CITY OF ALBUQUERQUE

May 26, 2023

Re: Blake's Lota Burger #27/ Drive-Thru Addition
2301 Carlisle Blvd. NE
30-Day Temporary Certificate of Occupancy
Transportation Development Final Inspection
Architect's Stamp dated 06-30-22 (H16-D106)
Certification dated 05-09-23

1 SITE PLAN - TRAFFIC CIRCULATION LAYOUT
1" = 20'-0"

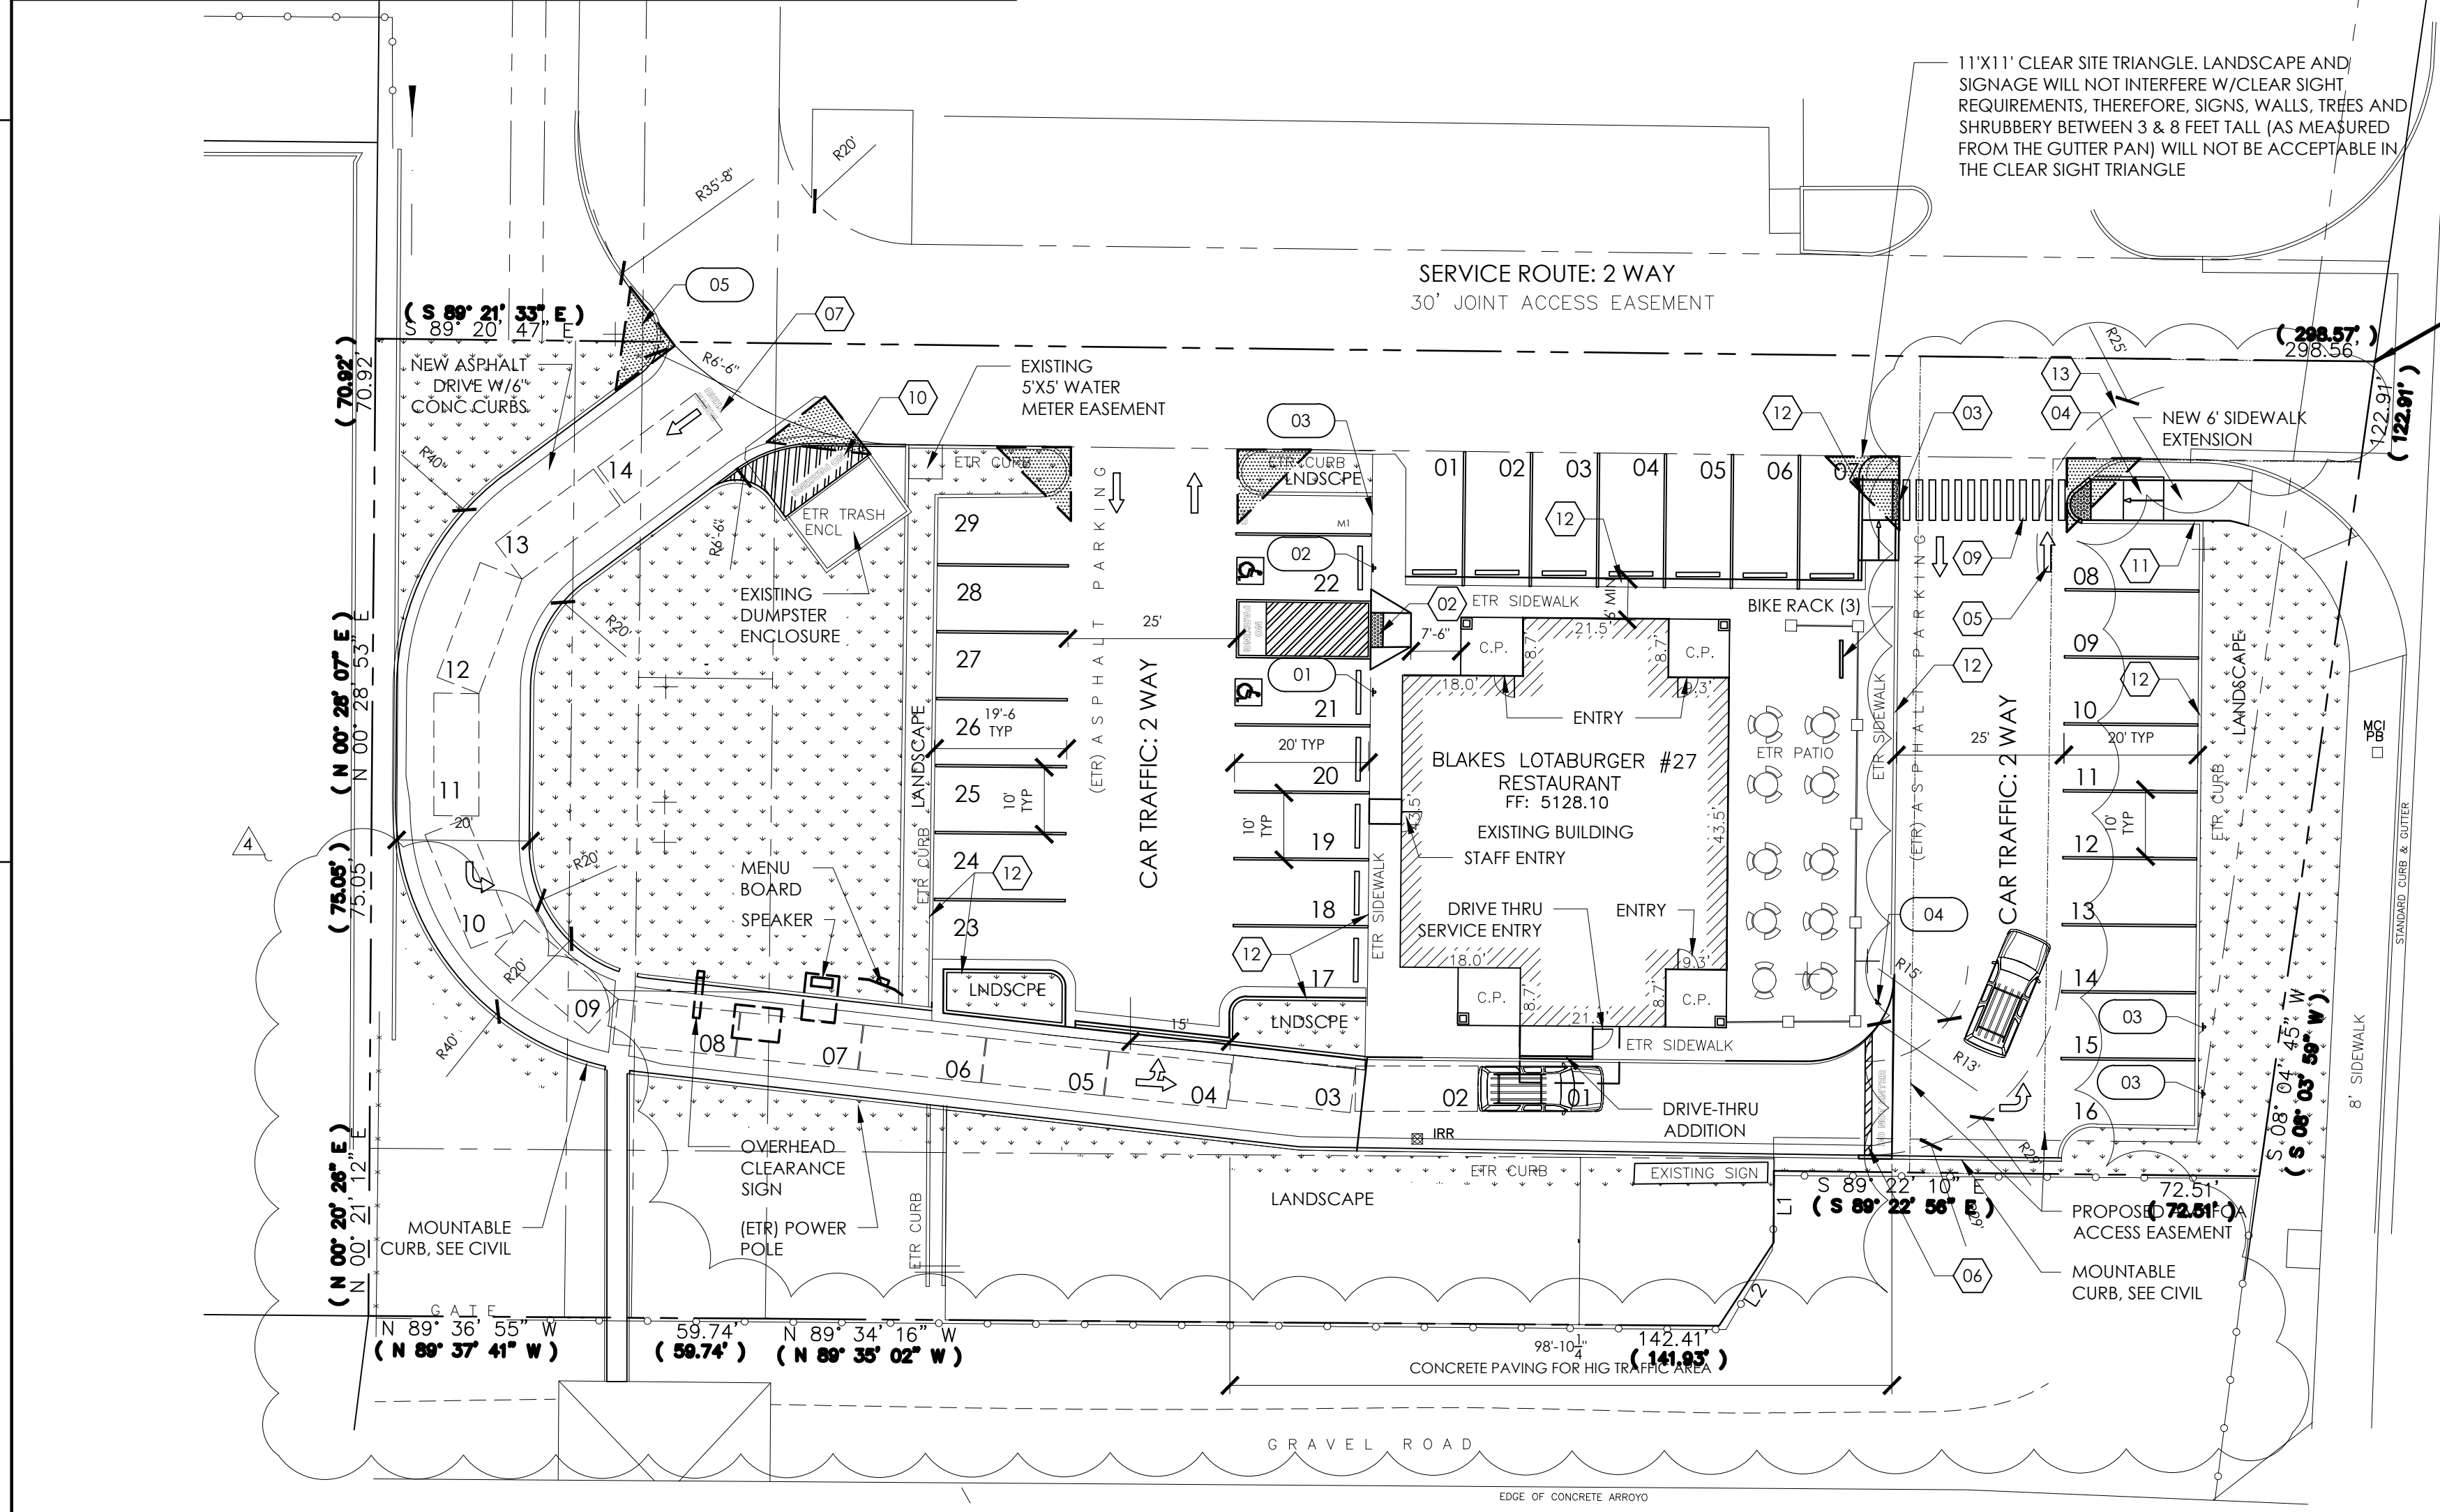
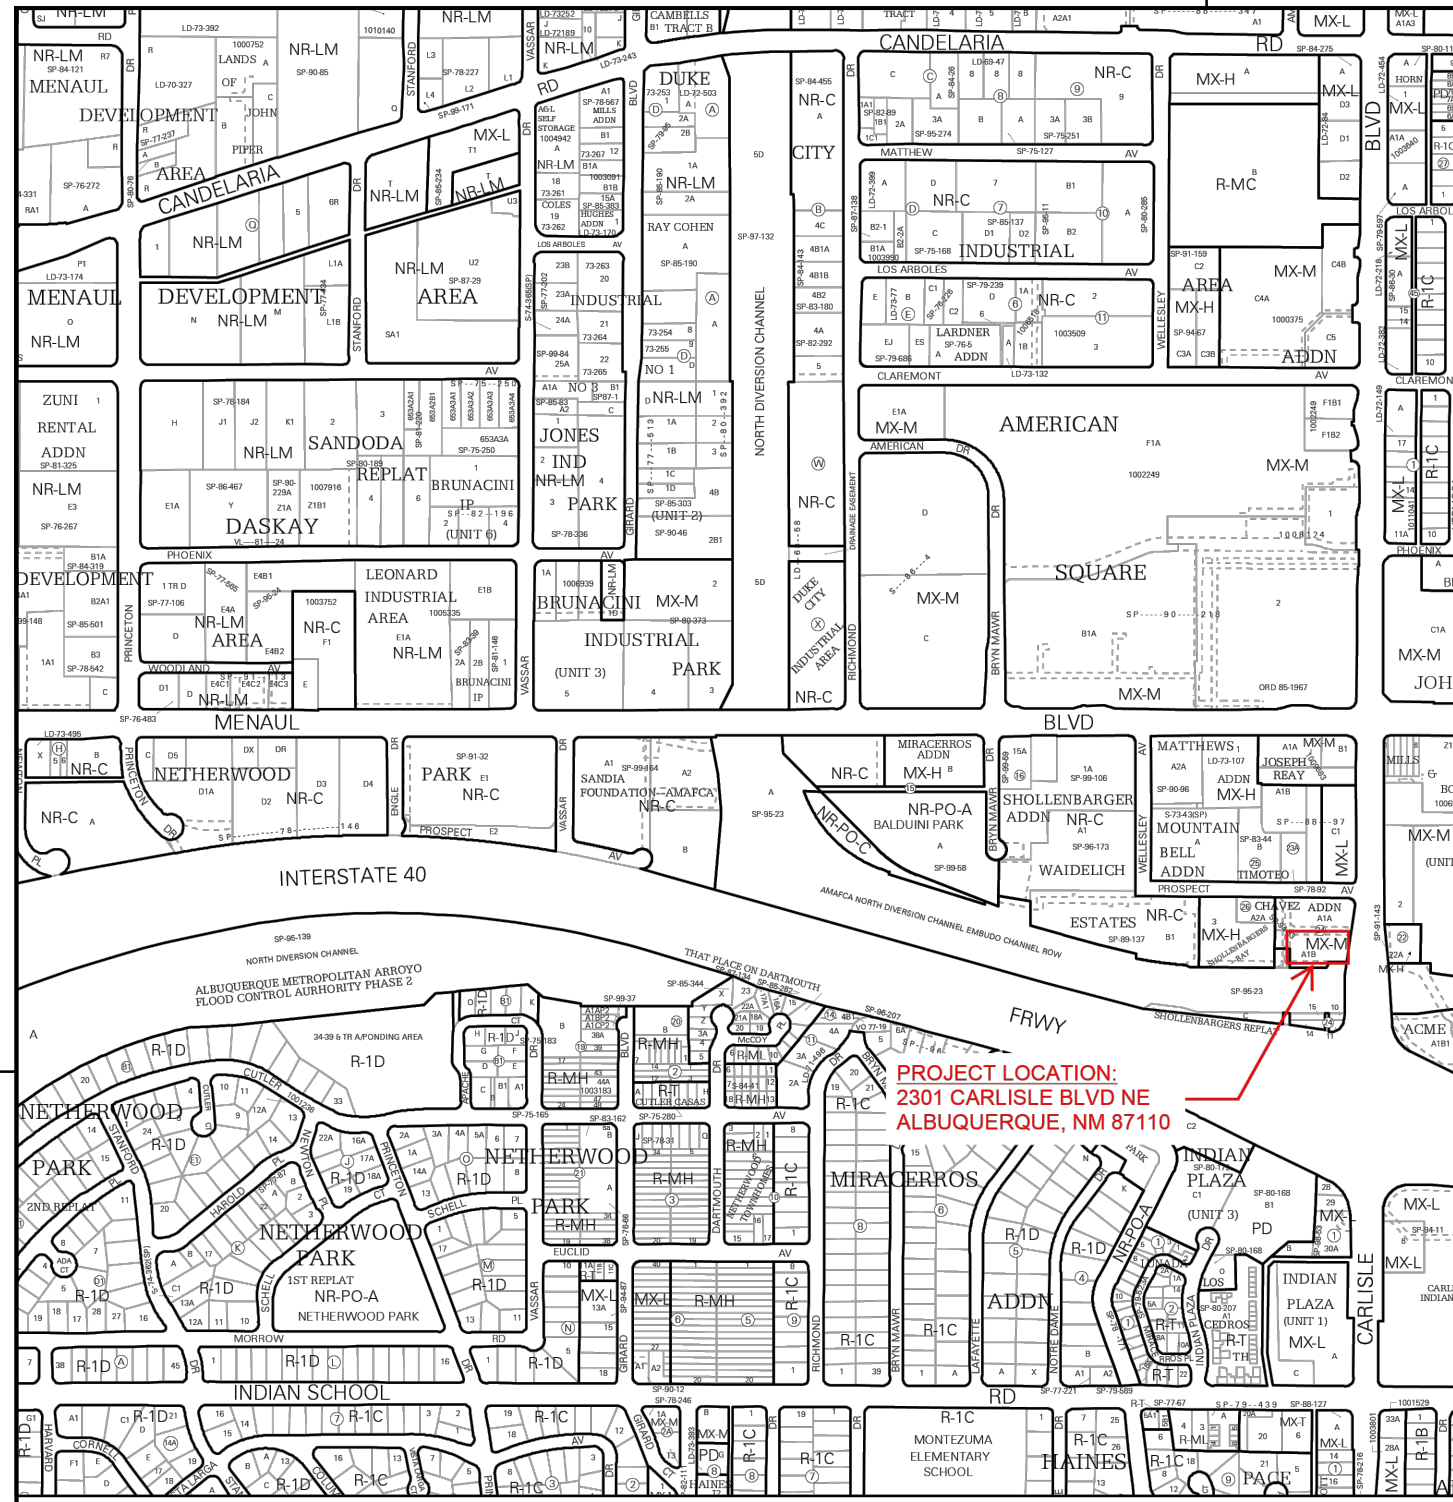
- Per approved plans, provide "DO NOT ENTER" sign at the exit of the drive-thru.
- Provide "MC" pavement marking. The pavement marking "MC" should be shown in the opposite direction for motorcycles entering the parking space
